Our Ref: FP/209/18/CLP
Your Ref:

Application for Lawful Development Certificate for a Proposed Use or Development

Development Lawful development certificate for a proposed single storey side extension.
Location 52 Downview Road Felpham

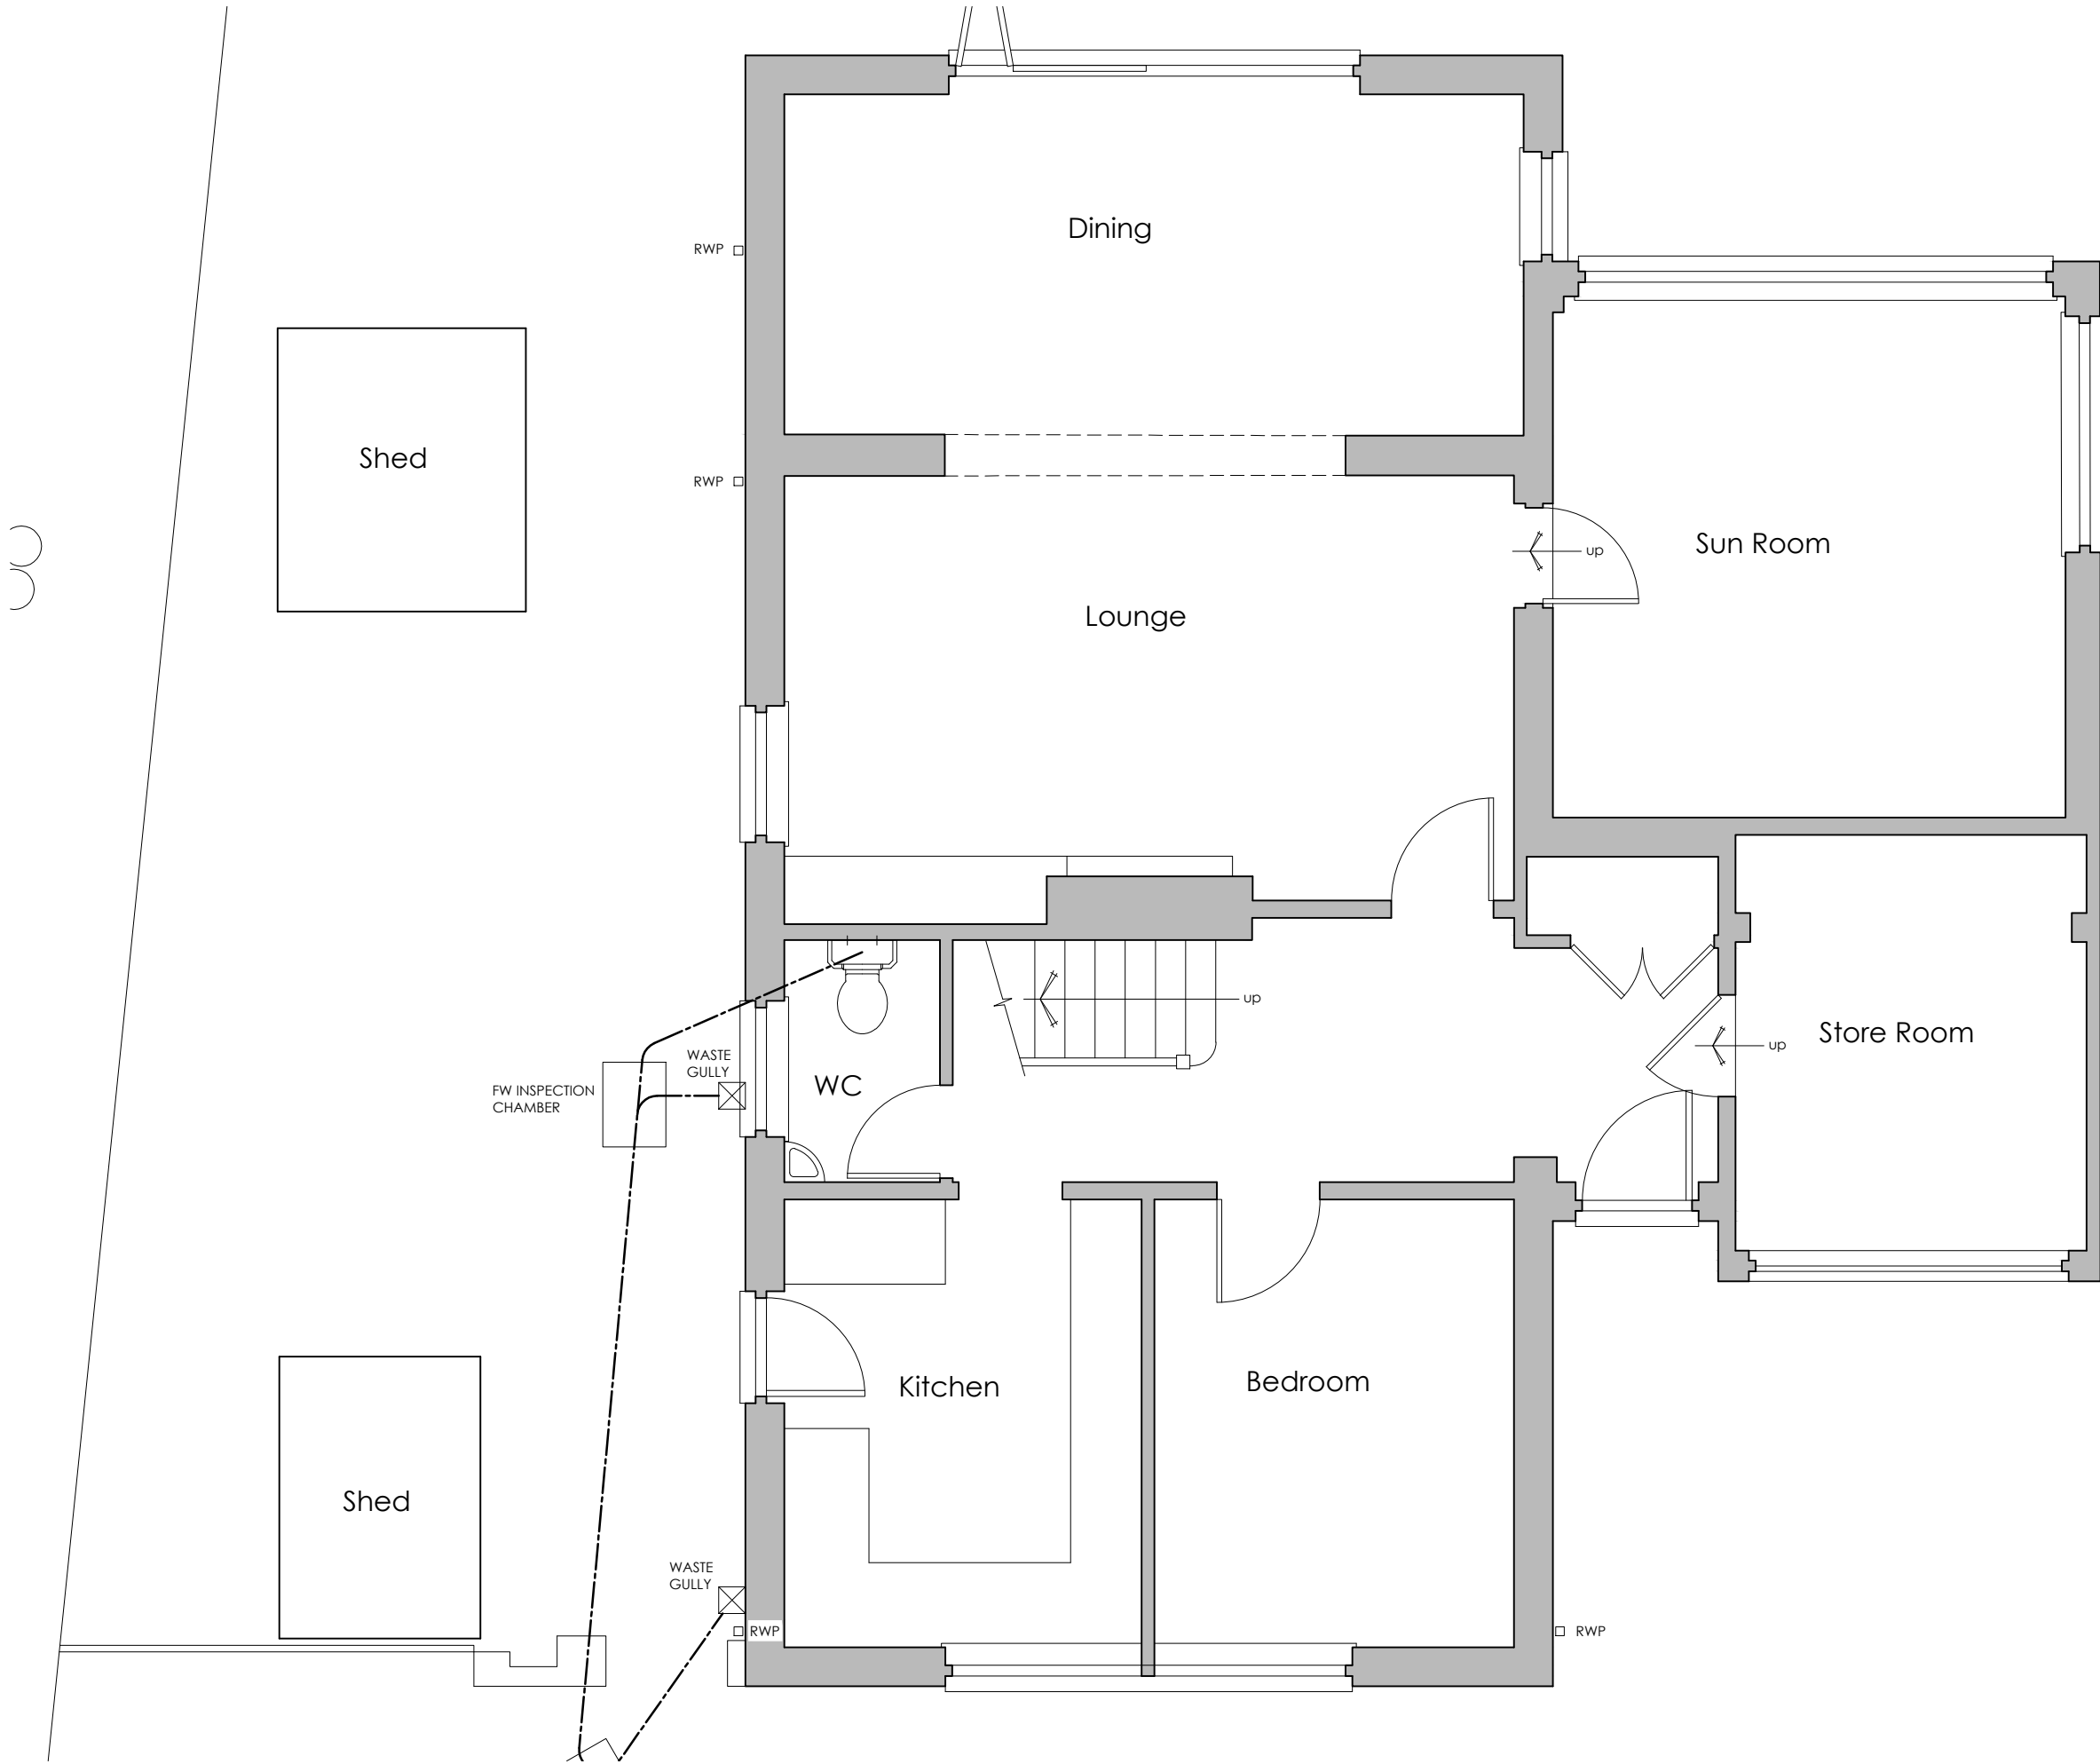
Two existiing floor plans have been submitted. Please retitle as existing and proposed floor plans as appropriate.
